**RE: Lot 14 Block 6 SAD 228
Volcano Cliffs Subdivision
6212 Camino Alto NW
Grading and Drainage Plan
Engineers Stamp Date 2/28/18 (D10D003B14)
CO Certification Dated: 8/7/19**

Based upon the information provided in your submittal received 8/7/19, this plan cannot be approved for Certificate of Occupancy until the following comments are addressed.

ENGINEER'S SEAL 2/28/18 DAVID SOULE P.E. #14522	6212 CAMINO ALTO CT NW WALTON RESIDENCE	DRAWN By WCVJ
	GRADING AND DRAINAGE PLAN	DATE 2-28-18 21844-LAYOUT-1-05-18
 Rio Grande Engineering 1606 CENTRAL AVENUE SE SUITE 201 ALBUQUERQUE, NM 87106 (505) 872-5998		SHEET # —
		JOB # 21844

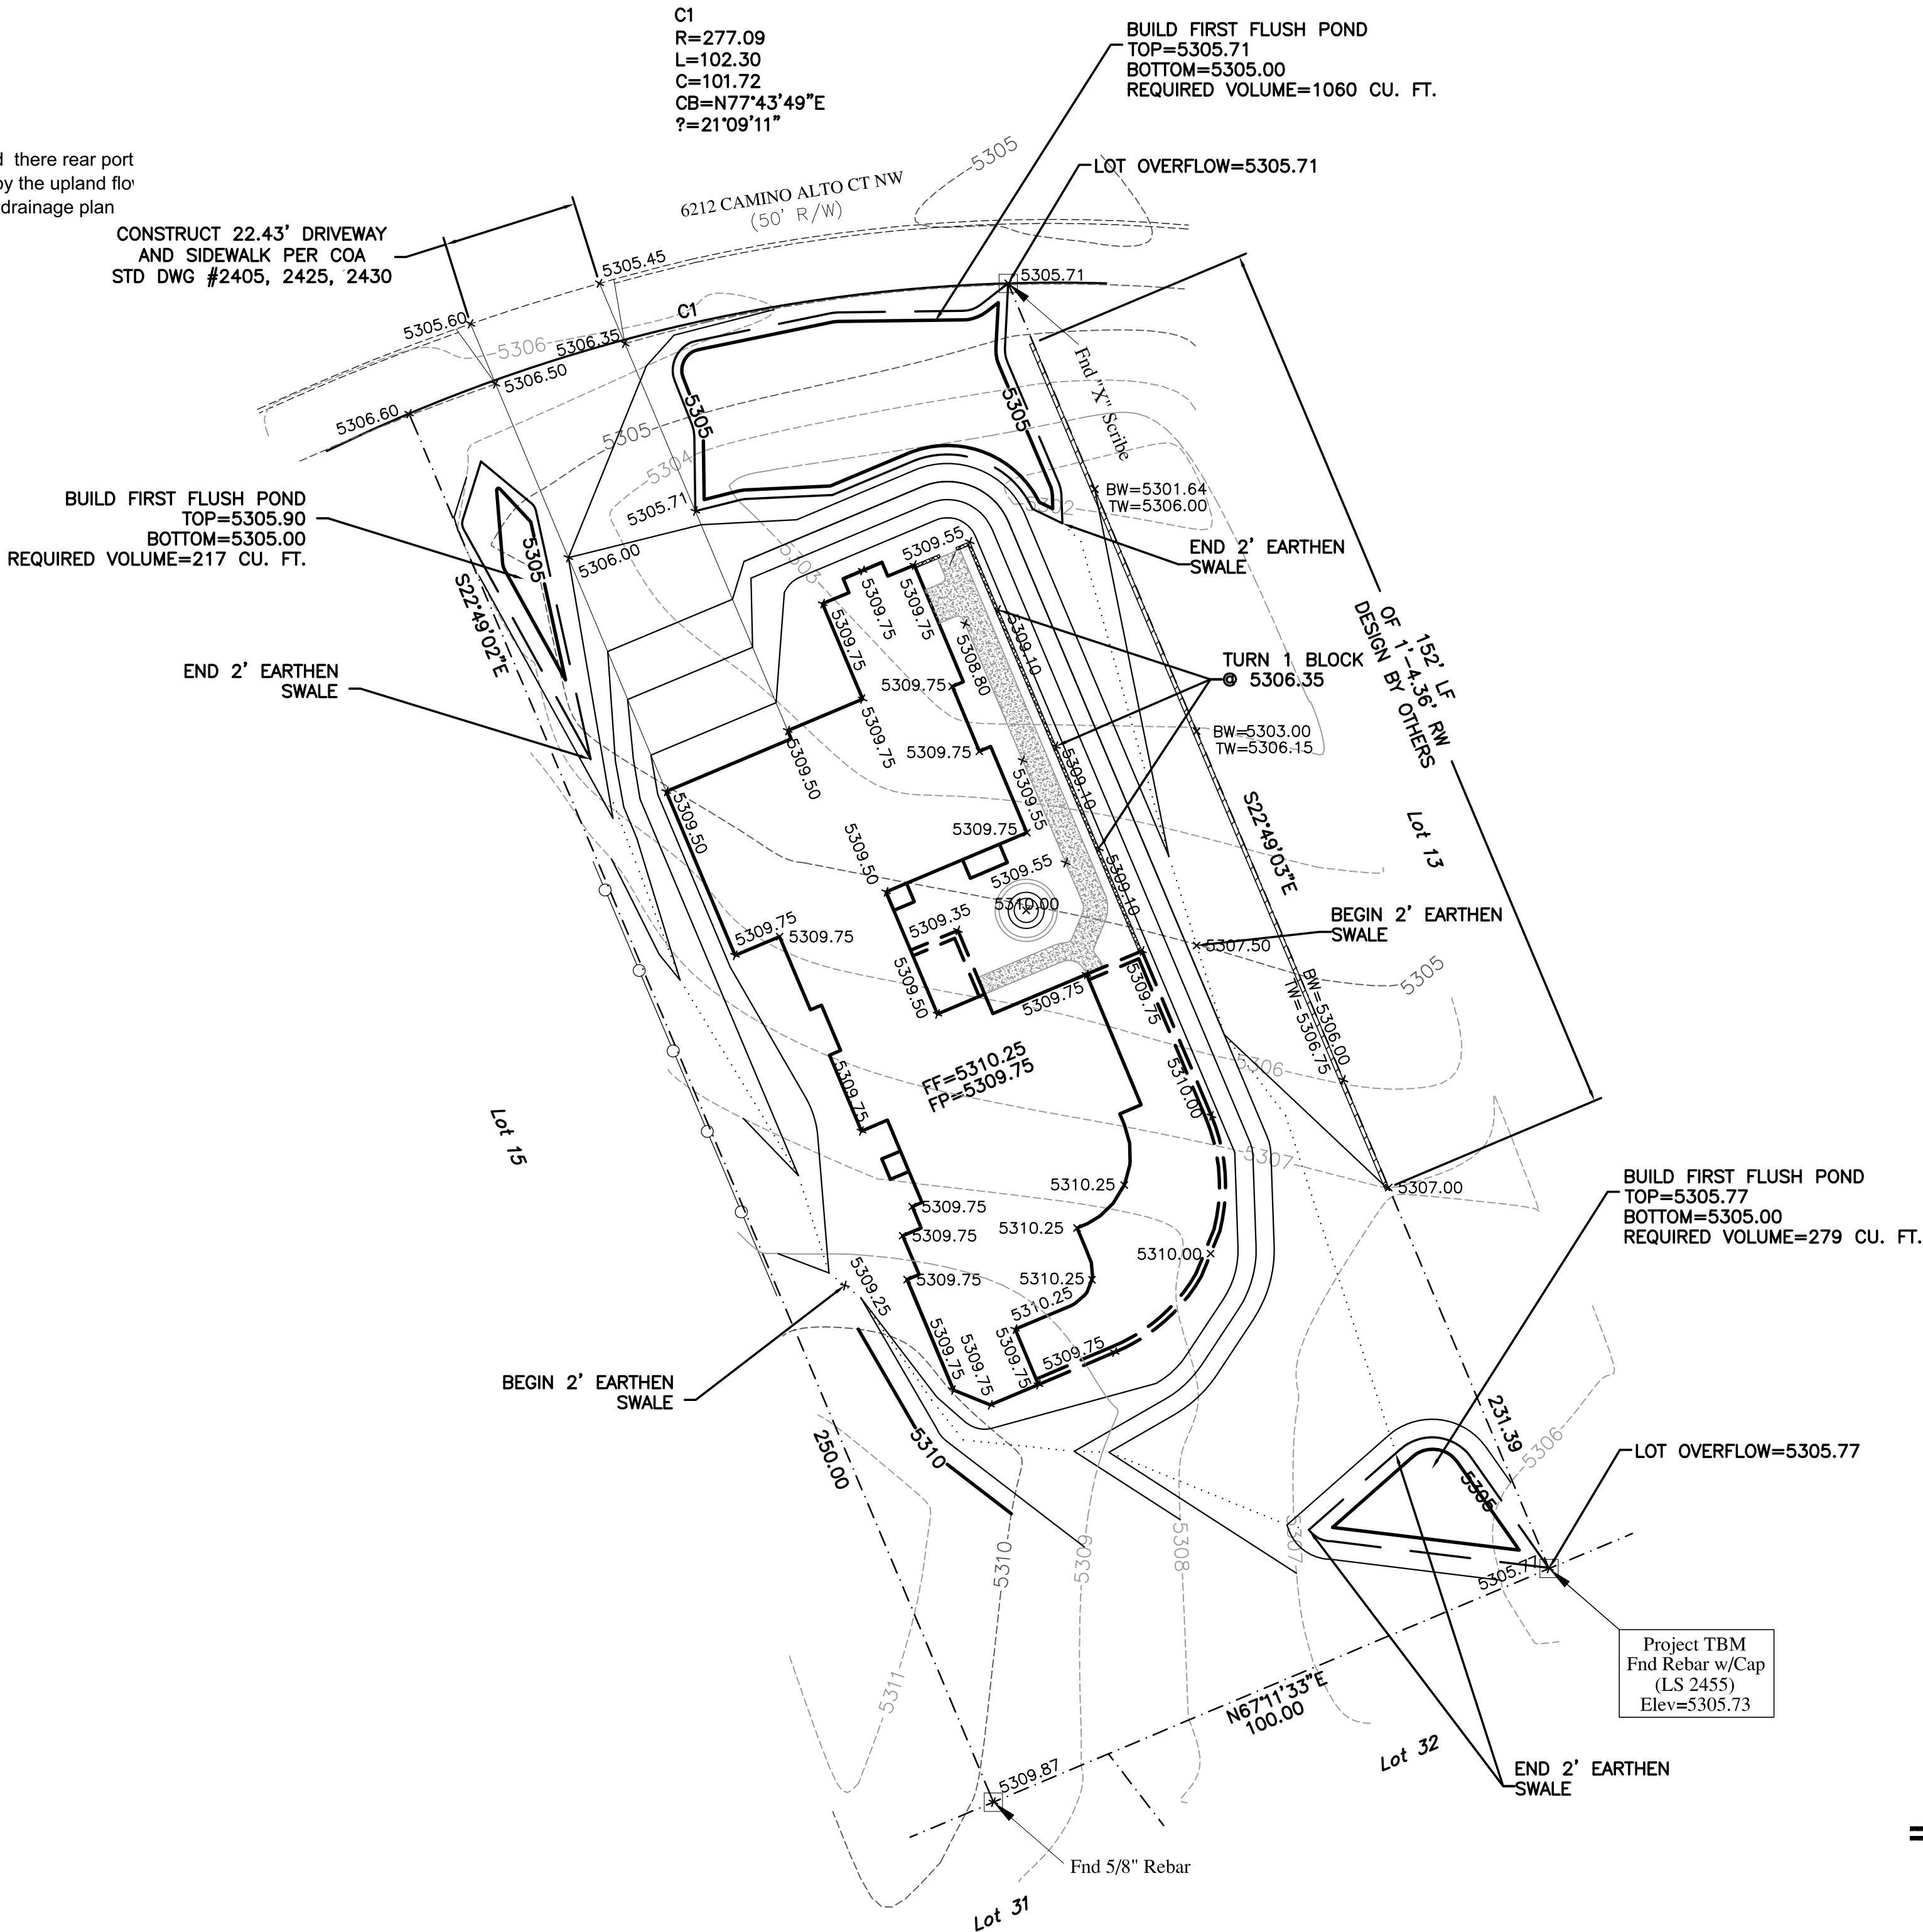
- There is erosion in the rear yard, sending sand into the Petroglyph area. Show how this will be prevented and have the owner fix the problem.
- There is erosion in the front yard from the pond into the neighbor's yard. Show how this will be prevented and have the owner fix the problem.
- Provide erosion protection in the front yard.
- Provide erosion protection in the west side yard.
